Pre-Application Advice – Written Response

1	Ref No: DM/2023/01501
2	<p>Site Address:</p> <p>150 Hereford Road, Monmouth, NP25 3GA</p>
3	<p>We understand your proposal to be: Adjustments to approval DM/2022/00461 - introduction of dormer construction to provide adequate headroom internally</p>
4	<p>What information our advice is based on: Site visit dated 9th November 2023 and the following supporting plans: - , 2055 - 30 - ,</p>
5	<p>Planning Policies you need to be aware of:</p> <p><u>Local Development Plan (LDP):</u></p> <p>DES1 LDP General Design Considerations</p> <p>EP1 LDP Amenity and Environmental Protection</p> <p>NE1 LDP Nature Conservation and Development</p> <p>S13 LDP Landscape, Green Infrastructure and the Natural Environment</p> <p>S17 LDP Place Making and Design</p> <p><u>Supplementary Planning Guidance (if any):</u></p> <p>Renewable Energy and Energy Efficiency SPG March 2016: http://www.monmouthshire.gov.uk/renewable-energy-energy-efficiency-supplementary-planning-guidance</p> <p>Green Infrastructure April 2015: http://www.monmouthshire.gov.uk/app/uploads/2015/07/GI-April-2015.pdf</p> <p>Domestic Garages SPG (January 2013): http://www.monmouthshire.gov.uk/app/uplo

FRONT ELEVATION AS PROPOSED (SCALE 1:100 @ A1)

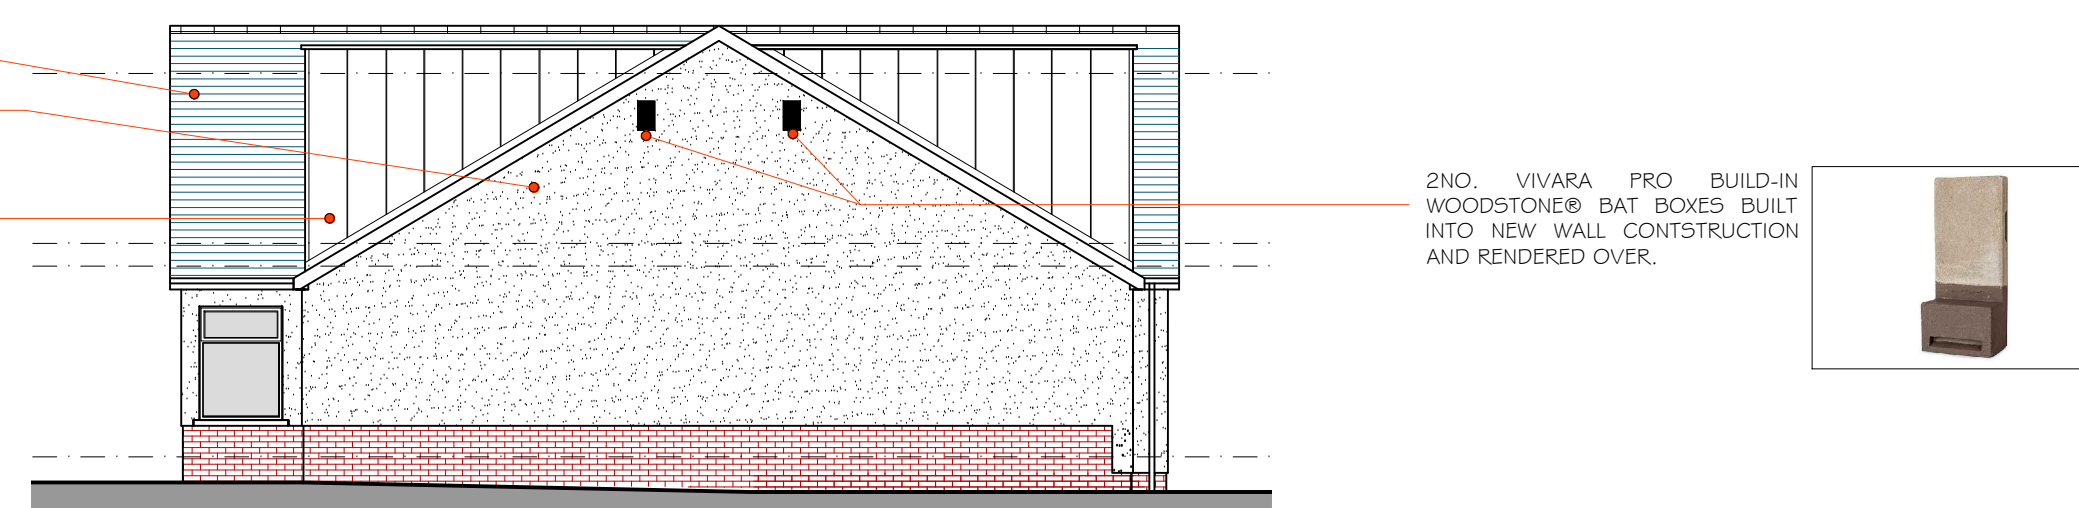
With regards to the principle elevation, which is proposed to introduce a box dormer to the principle elevation, this should be very carefully considered as to protect the streetscene of the area. Whilst I do note on site that we had a positive outlook on the development, upon further review and conversations with colleagues of the LPA I would now steer you away from the box dormer and instead look to keep it contained within the roof of the previously approved extension. So you could either reduce its size and go pitched roof dormer, which is a common feature within the area, I do note it will not give the fully increased internal space the applicant was looking for, but we are taking into account that this could be provided to the rear, potentially even keep the principle elevation as it is and extend further to the rear. Another option is that you can copy the rear extension to the front. At the moment it is neither fully traditional or contemporary which doesn't necessarily lead itself to a cohesive design. I would encourage the applicant to not use anthracite cladding and recommend zinc if possible in order to gain a high quality finish.

REAR ELEVATION AS PROPOSED (SCALE 1:100 @ A1)

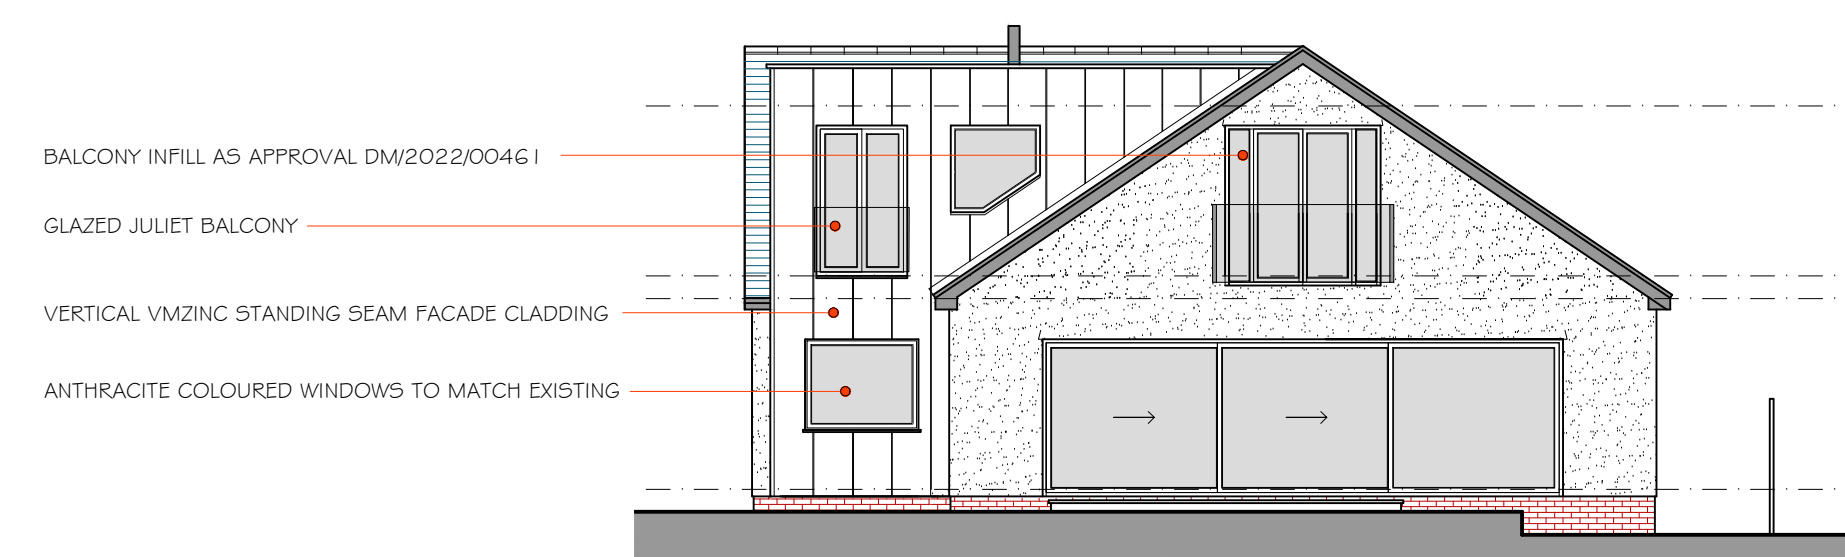
Regarding the extension to the rear, it is a contemporary approach and will offer the needed headspace for the applicants, the extension will project from the previously approved side extension at the site which has not yet been implemented, it is recommended that the applicant submits a new householder application as the works are considered material and therefore cannot be considered as an NMA. As the extension is to the rear, it is not considered to appear alien within the wider streetscene.

Care must be taken to ensure that no unsatisfactory loss of residential amenity is caused by the proposed works. The proposed juliet balcony to the rear is considered to have no adverse impacts on 148 Hereford Road. The alterations to the dwelling would see the removal of a first floor rear balcony, which had an element of overlooking and encourages the space to be used by the occupiers of the dwelling. The juliet balcony, unlike a balcony does not encourage the space to be used, it is therefore considered that given the existing context of the site, there will be no increase in overlooking as a result of allowing a juliet balcony.
